The Drovers Solar Farm

Statement of Common Ground (SoCG) with Environment Agency (Clean)

PINS reference: EN0110013

Document reference: APP/5.13.1 (Revision 1)

DRAWING TITLE:
Figure 12.13: Work No. 2 Maximum Potential Foundations and Groundwater Elevations

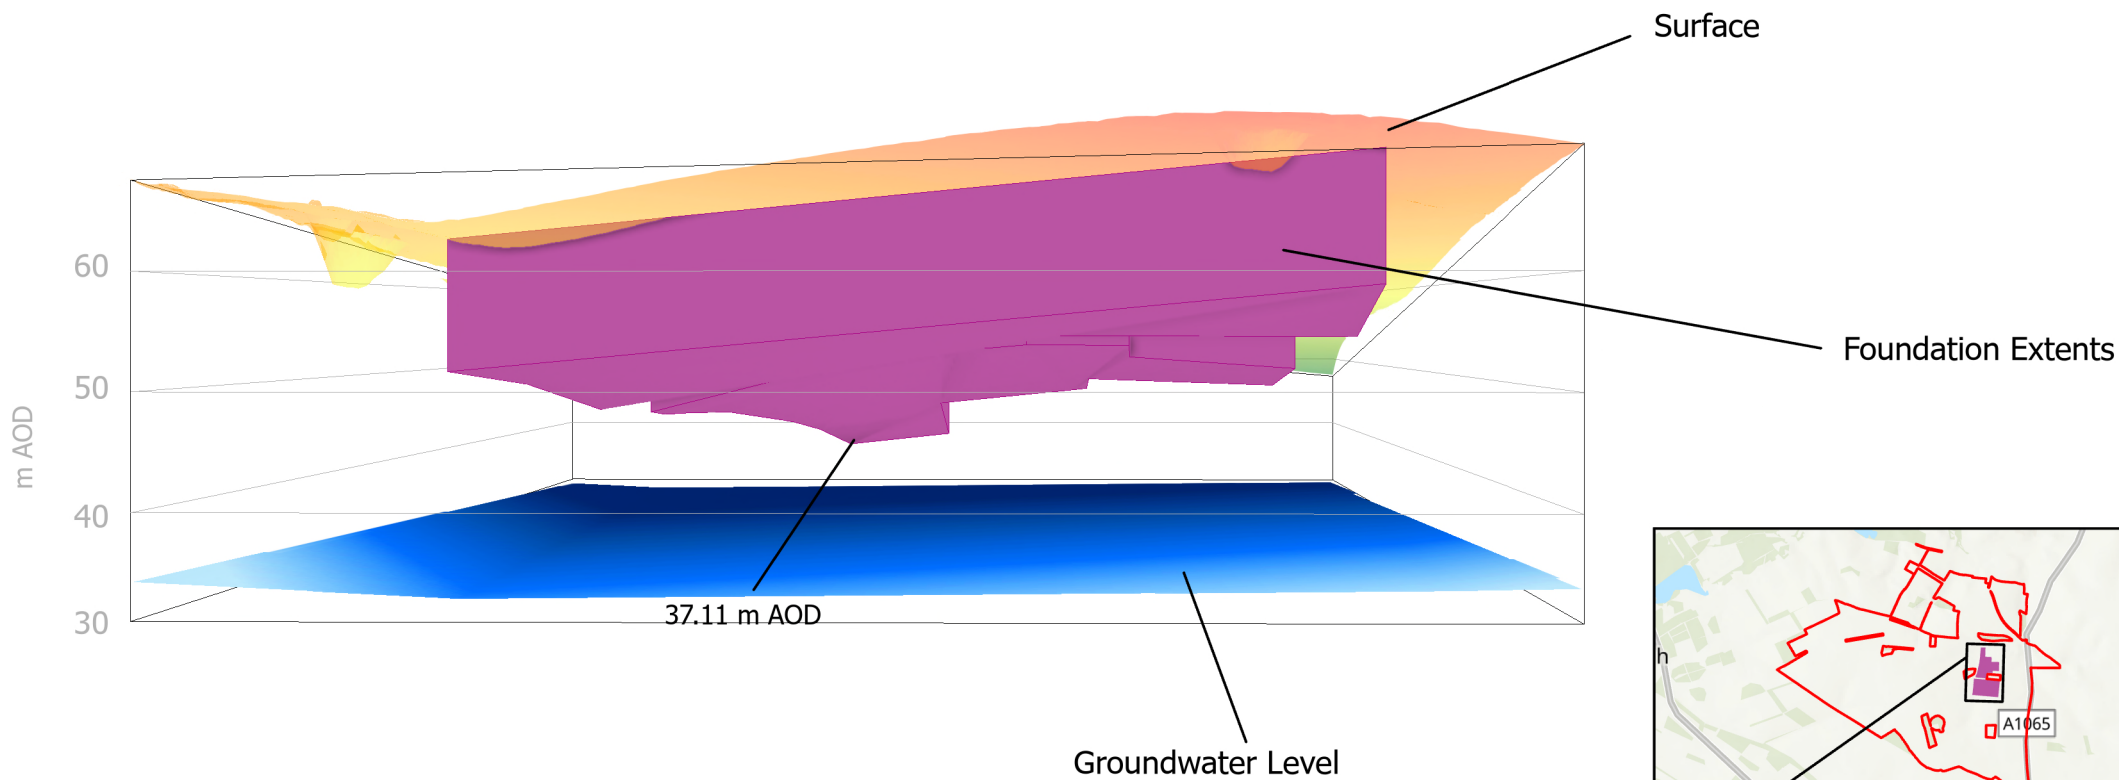
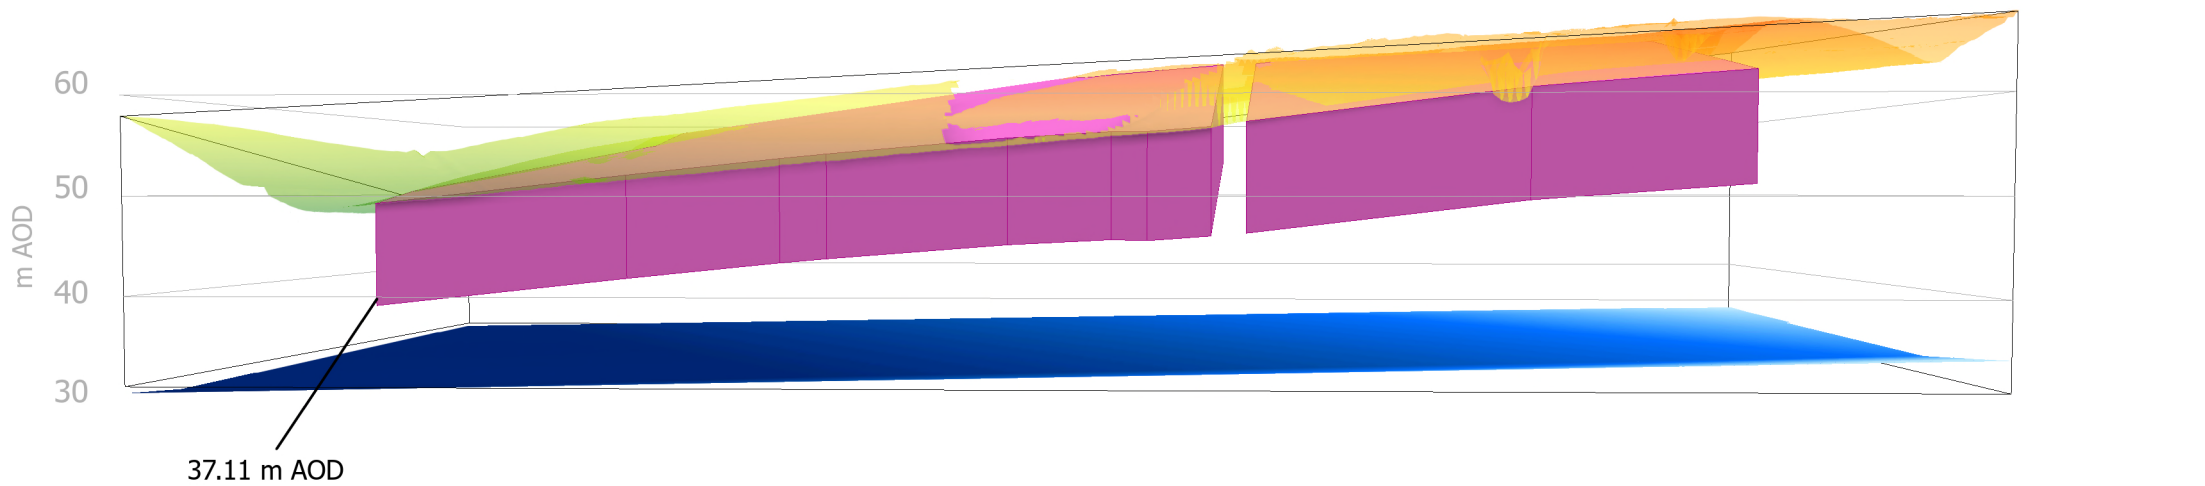
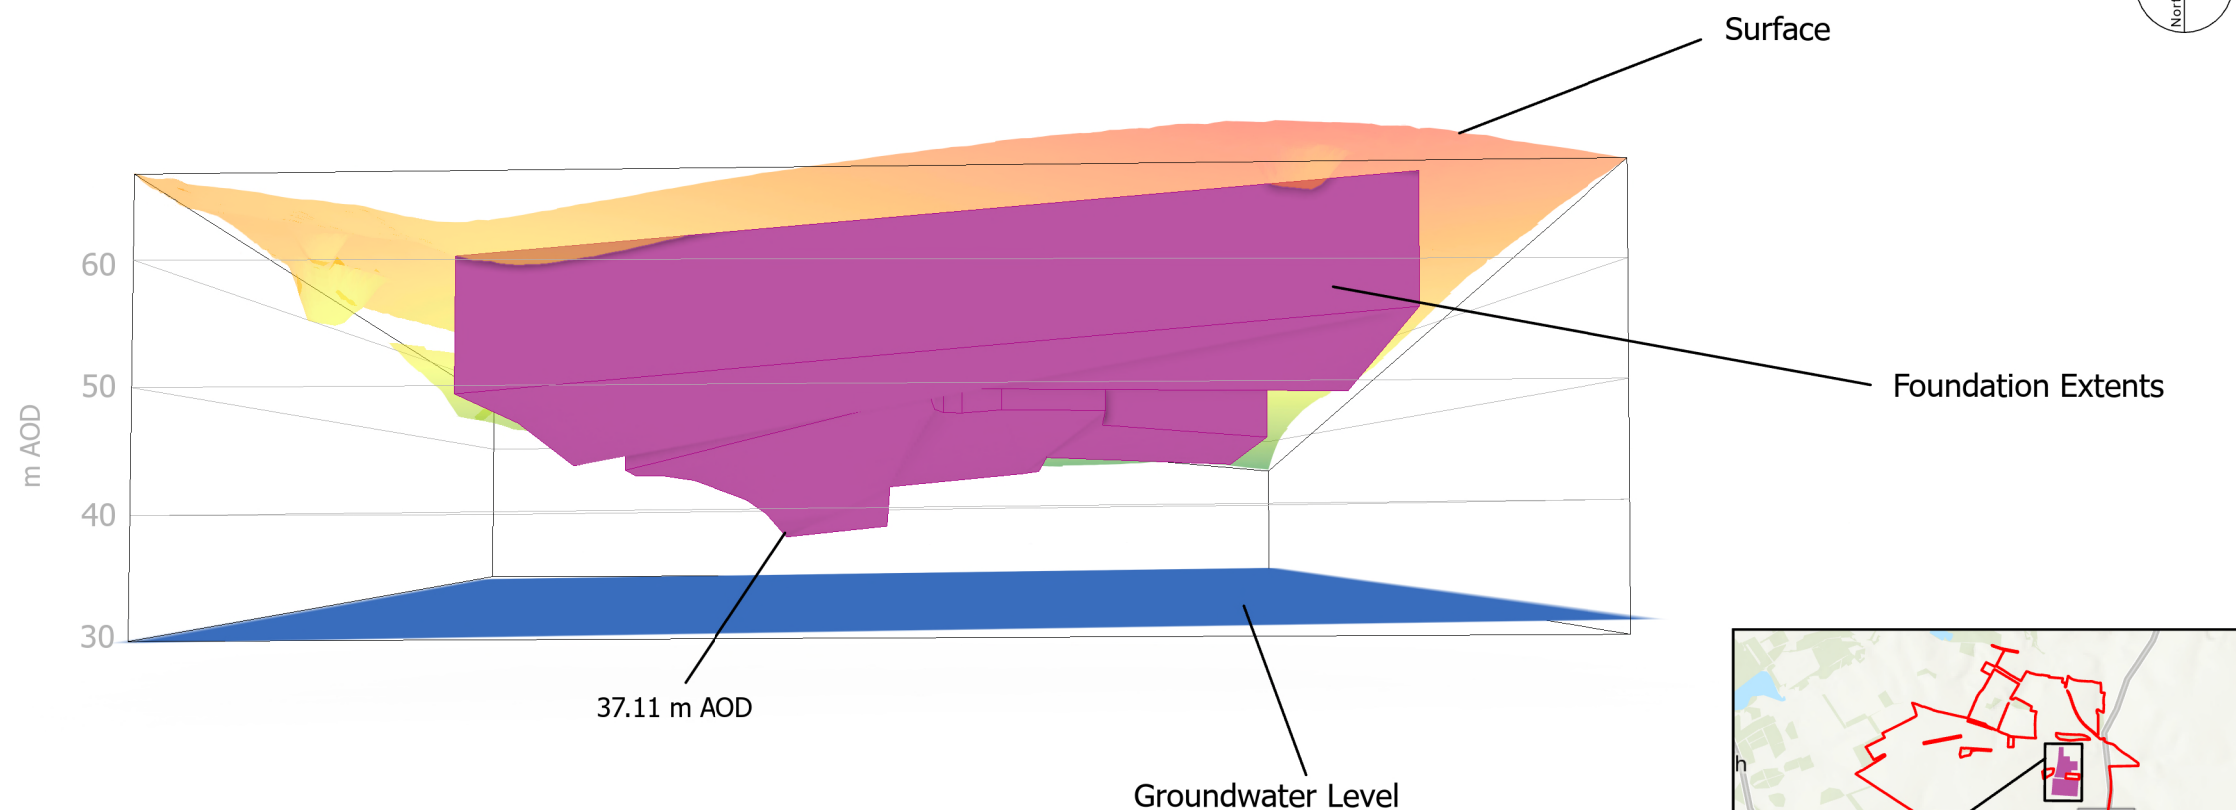
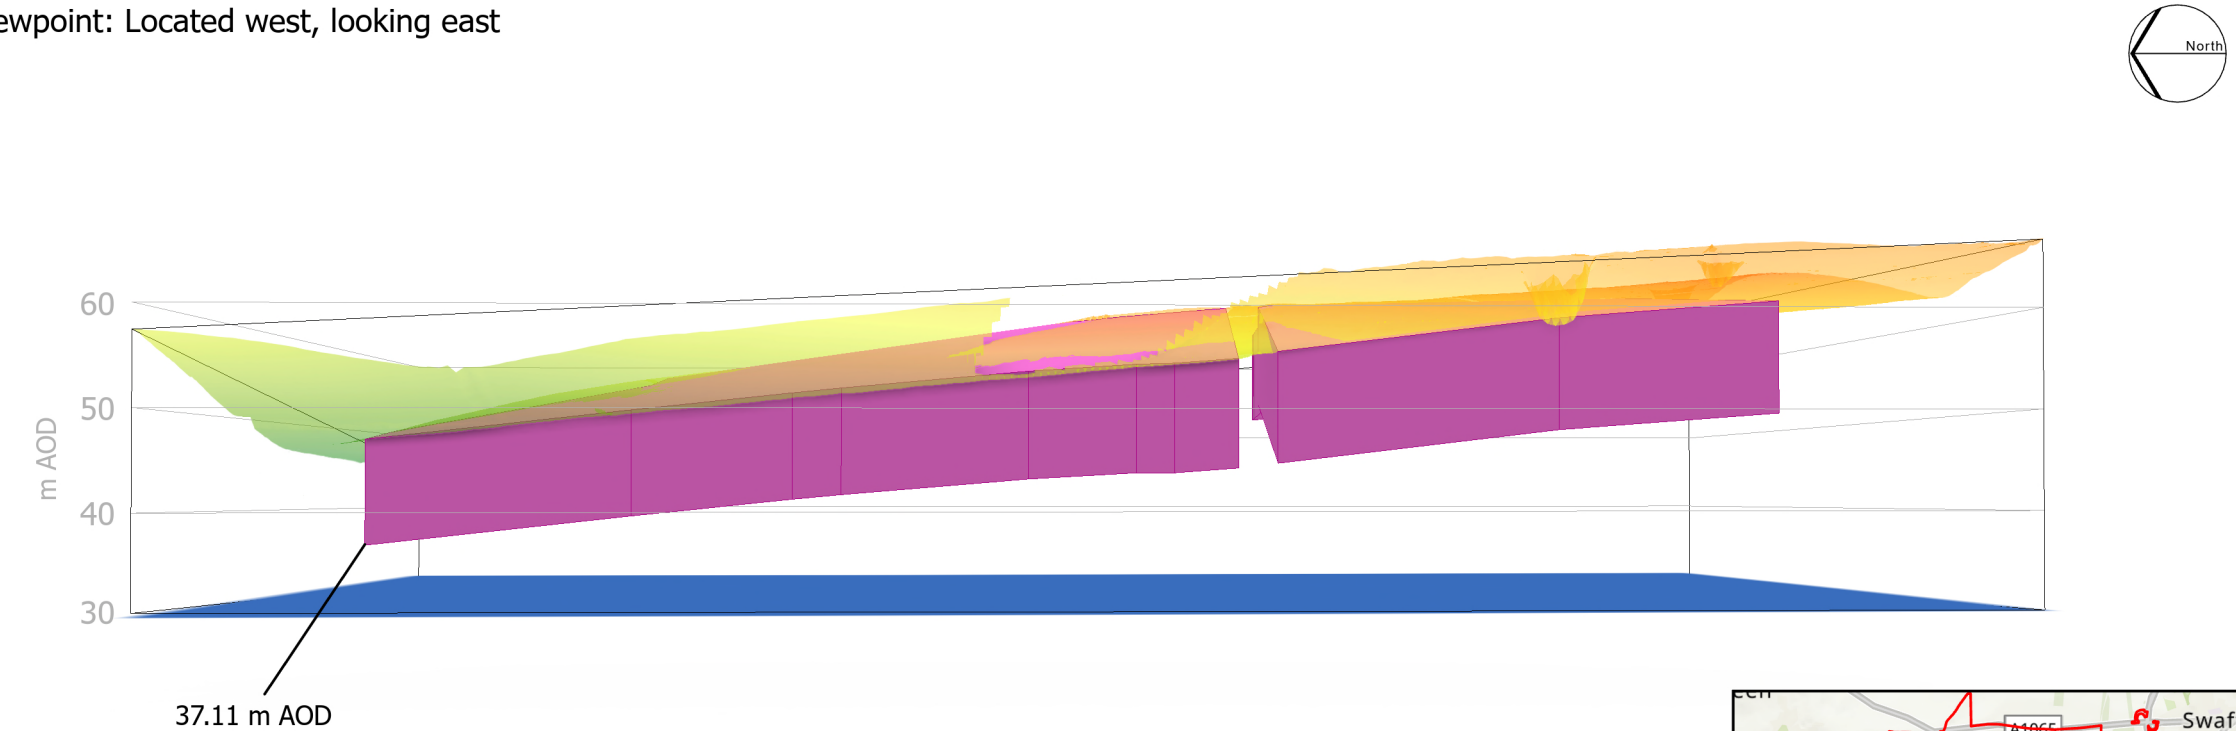
Reference	EA Issue Reference	Topic	Consultee's Position	Applicant's Position	Status
2-1	EA05	Maximum Foundation Extents	Figure 12.13 Work No.2 Piling Locations within CSA for Maximum Groundwater Level [APP-127] Figure 12.14 Work. No 3 Piling Locations within CSA for Maximum Groundwater Level [APP-128] Figure 12.15 Work No. 4 Piling Locations within CSA for Maximum Groundwater Level [APP-129] Figure 12.16 Maximum Foundation Extents for Minimum Groundwater Level [APP-130] Issue: Figures 12.13 to 12.16 do not clearly show the orientation of each 3D model view,	Figures 12.13 to 12.16 of ES Chapter 12: Water Resources [APP-061] were used to illustrate the maximum groundwater elevation surface across the Core Study Area and identify where proposed foundation depths could theoretically intercept shallow groundwater under worst-case conditions. The figures also demonstrate at a concept level where piling may be required depending on foundation design. The following changes have been made at Deadline 3 to aid the EA's interpretation: Addition of orientation labels or description	Medium

and the elevation of the maximum extent of foundations is not given. Impact: Difficulty in interpreting figures. Solution: Revise figures to more clearly define the area represented in the drawings, including view orientation, and the maximum foundations extent should be shaded to show elevation values. The model should be updated to inform detailed foundation design, based on site specific survey and monitoring data. Additional Comments: Use of inconsistent terminology may also result in confusion. Figures 12.13 to 12.15 are titled to show the anticipated extent of piling in comparison with the maximum groundwater level. In the context of the data presented, the maximum groundwater level in mAOD represents the shallowest extent and therefore worst-case condition for groundwater. For clarity the report should preferably refer to groundwater 'elevation' (in mAOD) as is represented within the figures rather than 'level', which could be misinterpreted as relative to ground level rather than Ordnance Datum. Figure 12.16 shows the minimum (i.e. deepest) groundwater elevation (i.e. best case) in relation to anticipated piling depth. Although this is useful information, this could potentially be misinterpreted by the reader as presenting a combined overview of the	- Elevation shading to show mAOD values for the maximum groundwater elevation surface and foundation extent surface - Highlight areas where foundations intersect or exceed groundwater elevation surfaces; and - Figures and text refer to groundwater elevation (mAOD) rather than groundwater level to increase clarity between absolute elevation and depth below ground. The Applicant agrees that the conceptual model present is not the final tool for foundation design, but rather to provide a screening-level assessment of groundwater conditions and to identify areas needing piled or shallow foundations and will be aligned with EA regional groundwater understanding (NEAC model). The Design Principles, Parameters Commitments [APP/5.8.3] have been updated at deadline 2 to commit to foundations not directly interacting with groundwater.
